Appeal Decision

Appeal Ref: APP/R5510/D/24/3341936

123 Charville Lane, Hayes, Hillingdon UB4 8PD

- The appeal is made under section 78 of the Town and Country Planning Act 1990 (as amended) against a refusal to grant planning permission.
- The appeal is made by Mr Habib Burhani against the decision of the Council of the London Borough of Hillingdon.
- The application Ref. is 8692/APP/2023/2858.
- The development proposed is extensions and loft conversion including dormers.

PROPOSED FIRST FLOOR PLAN
1:100 @A3

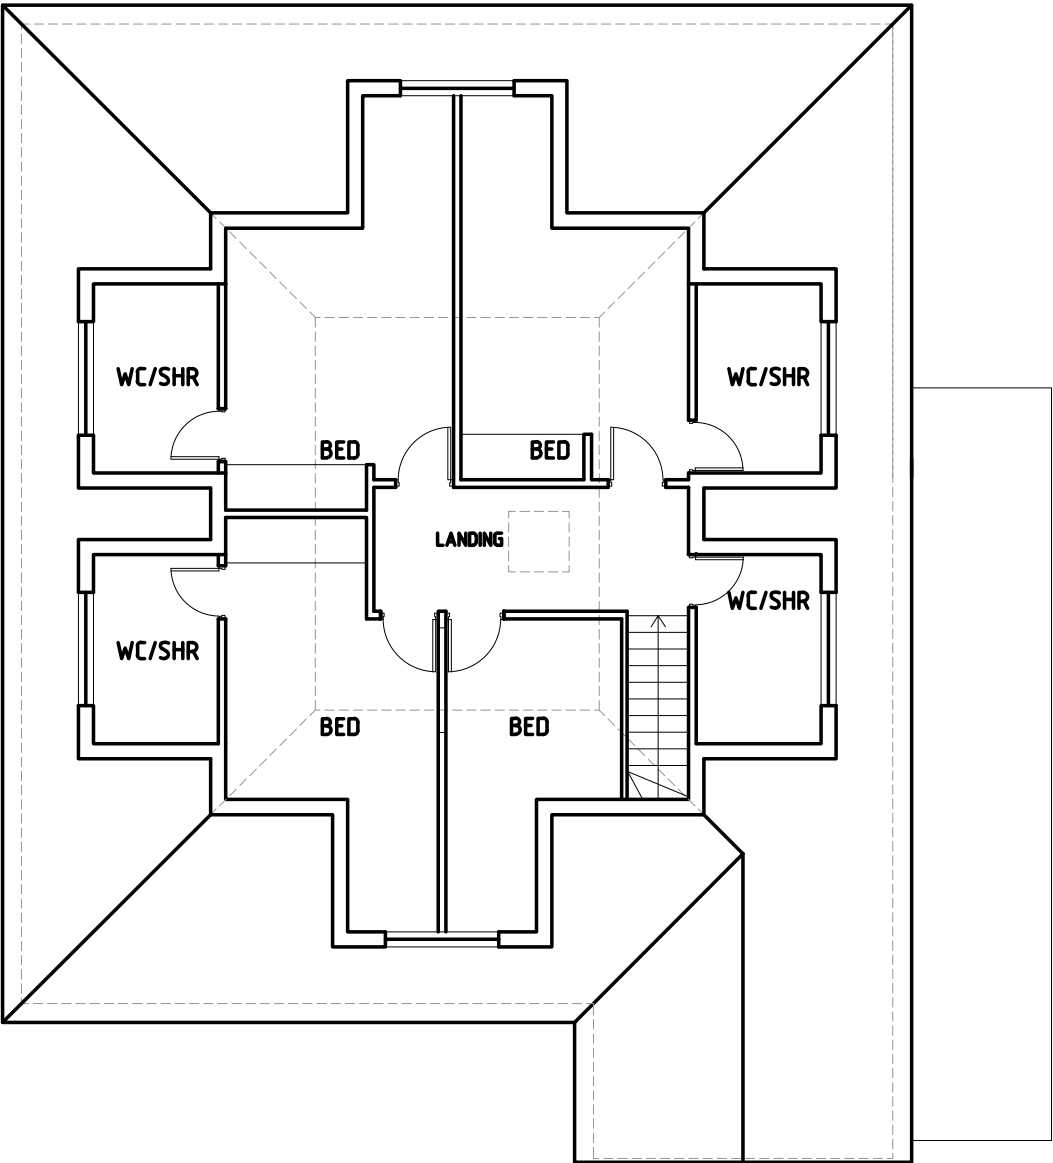
- 13.In the roof space, two proposed bedrooms at the rear and two proposed bedrooms at the front would each be served by one dormer window which would have a vertical intersecting wall dividing each of the two windows in two. The amount of natural light reaching each of those bedrooms would be extremely low, especially as each is an L-shape and the main floor area of each bedroom is located away from the windows making it hard for light to penetrate the main part of each bedroom.

- 14.Turning to consideration of the living conditions of a future occupant, the 'half' window serving each room would be unacceptably small and also distant from the main area of the bedroom. This would give an undue sense of enclosure and oppressiveness for any occupant of those bedrooms. In relation to the potential for ventilation there would be a top light opening window for each bedroom and I consider that this, on balance and taking account of the configuration of rooms on the proposed upper floor, would be sufficient to adequately ventilate the bedroom.

- 15.I therefore consider that there would be an unacceptable level of light and outlook to the first floor bedrooms causing unacceptable living conditions for current and

PROPOSED REAR ELEVATION 1:100 @A3

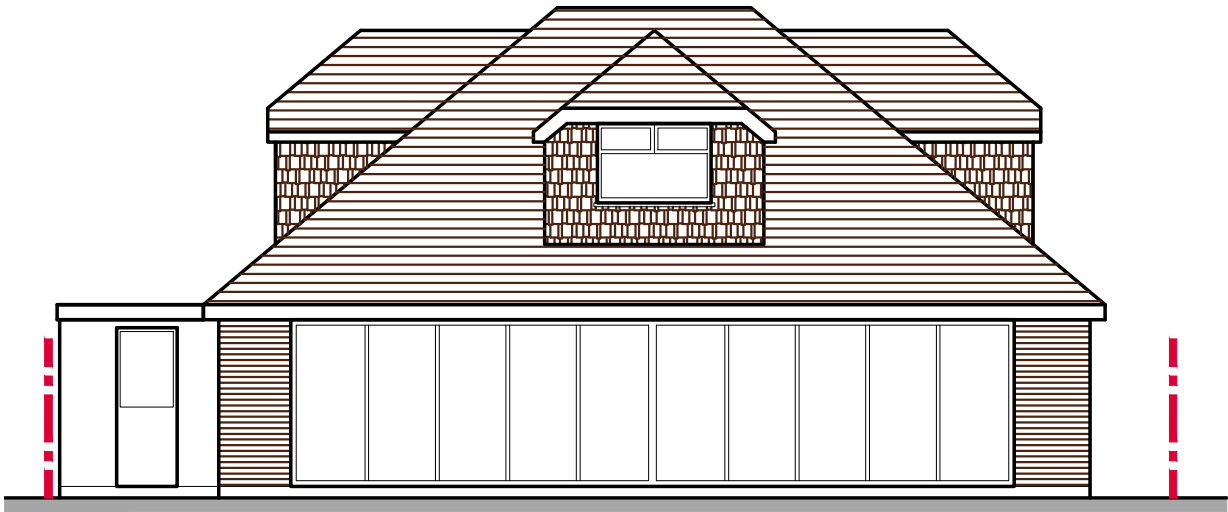
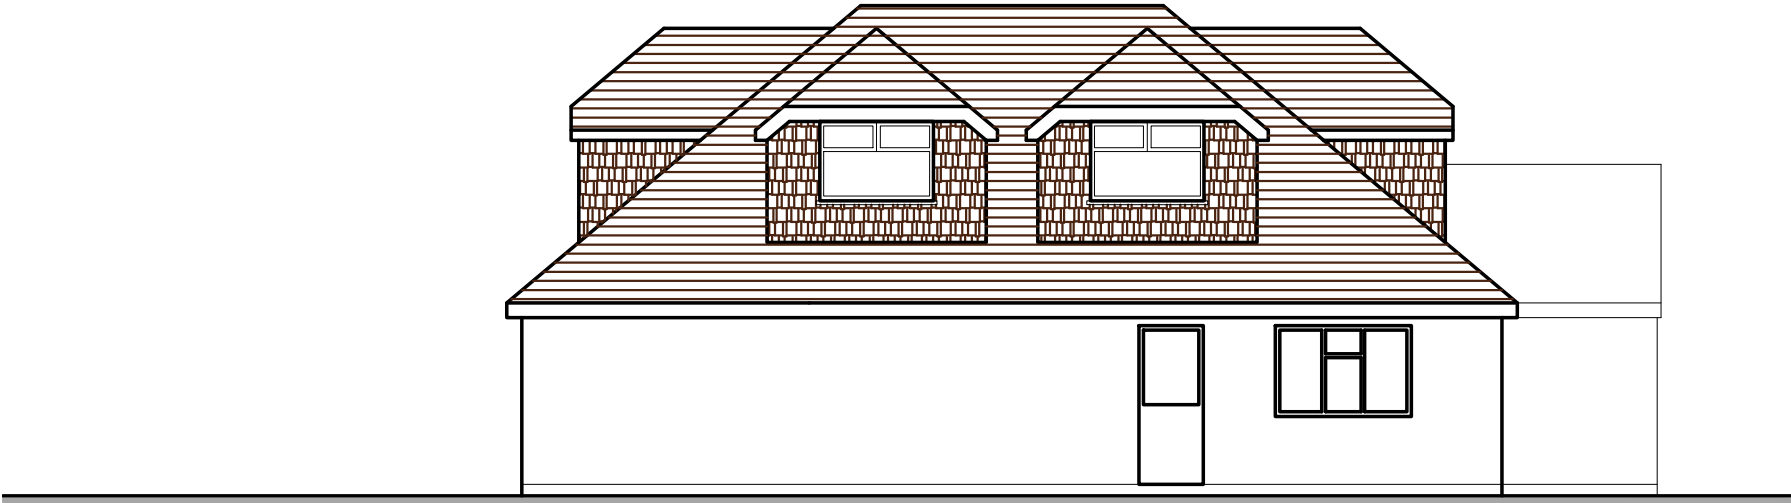
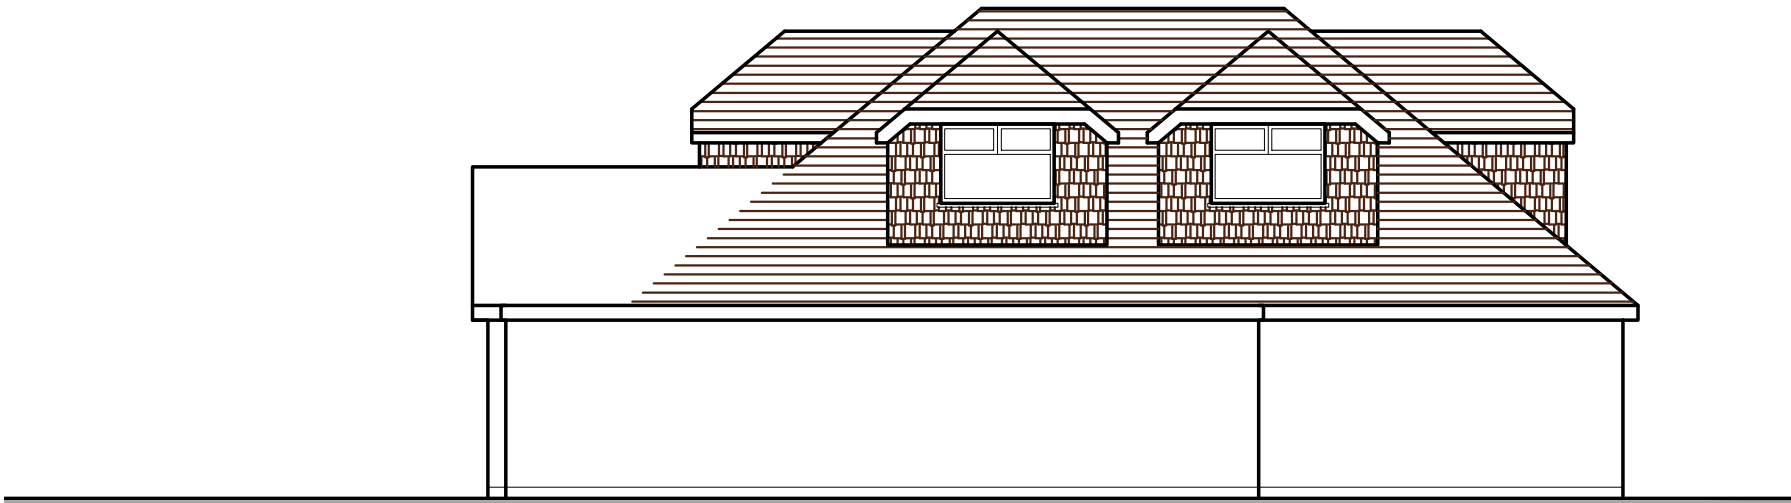
- 10.Turning to the dormers, two are proposed in the west roof slope, two in the east roof slope, one in the front roof slope and one in the rear roof slope. Whilst each is proposed with sympathetic pitched roofs with front hips, the size and number would overwhelm the modest appearance of the dwelling resulting in a cluttered, disproportionate and top heavy appearance to the dwelling. They would dominate the dwelling. This would be exacerbated by the fact that from the front the dwelling already appears unduly squeezed into its plot in terms of its width, leaving only a modest gap between the western flank and the common boundary with no.121 Charville Lane and a single storey side extension on the eastern flank of the dwelling being built almost up to the common boundary with no.135 Charville Lane to the east.

- 12.On this issue, I conclude that the proposed dormers would significantly harm the character and appearance of the host dwelling and would be contrary to policy BE1 of the Hillingdon Local Plan: Part 1 - Strategic Policies (adopted 2012), policies DMHB 11 and DMHD 1 of the Hillingdon Local Plan: Part 2 - Development Management Policies (adopted 2020) and policy D3 of the London Plan (2021).

PROPOSED GROUND FLOOR PLAN
1:100 @A3

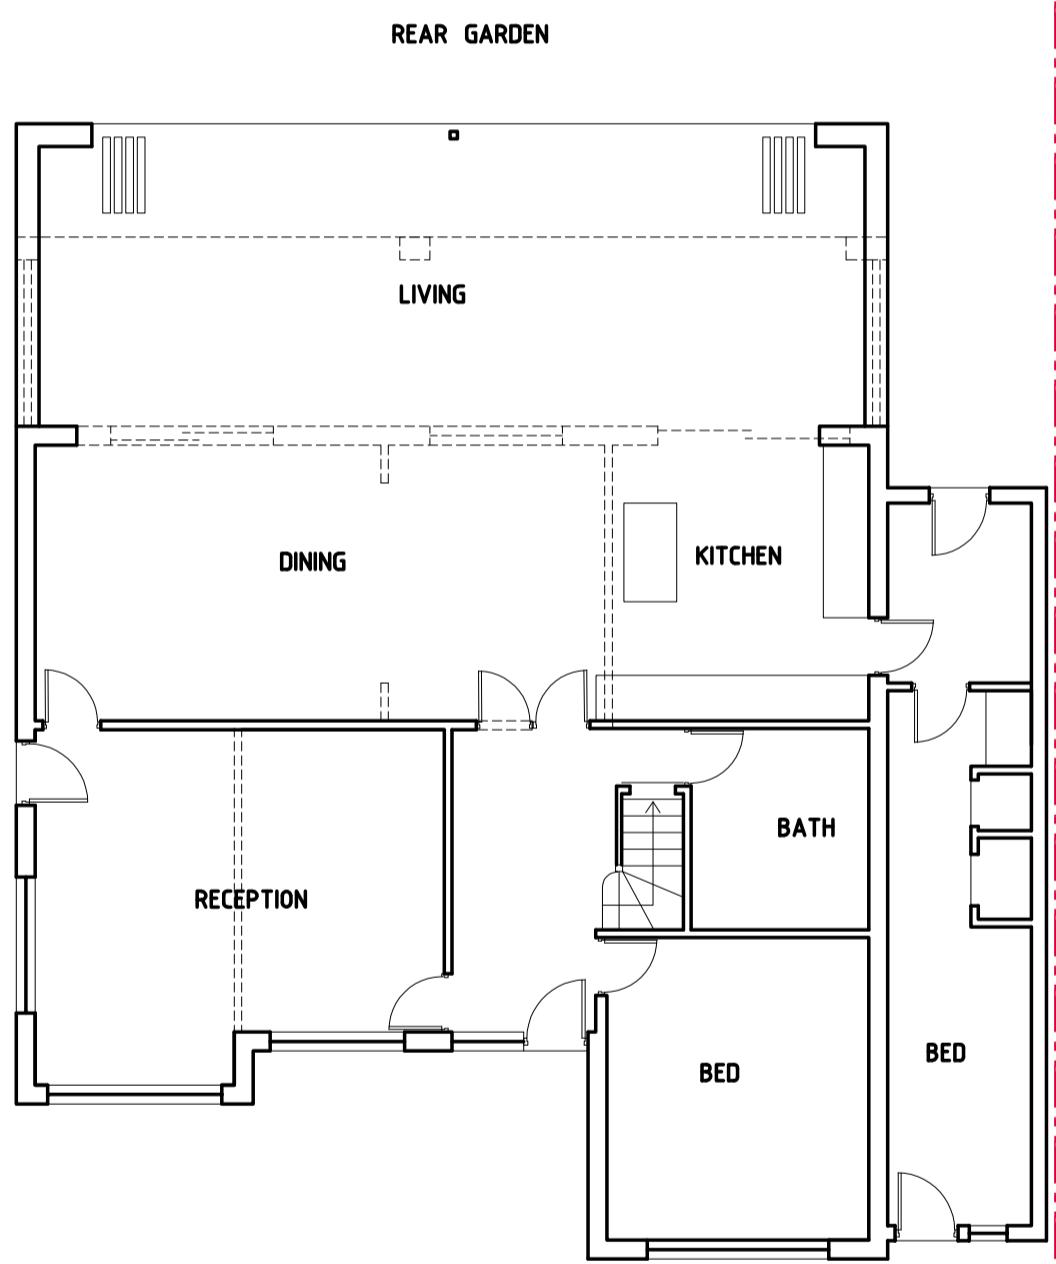
5. The proposed development includes a rear extension with habitable roof accommodation and 6 dormer extensions (1 x front, 2 x right side, 2 x left side & 1 x rear). The rear extension would measure approximately 4m beyond the original rear building line, span the full width of the rear of the property and match the ridge height of the existing dwelling. It would replace an existing conservatory at the site.

9. In terms of potential harm to the character and appearance of the host dwelling from the proposed rear extension, I consider that owing to it being at the rear of
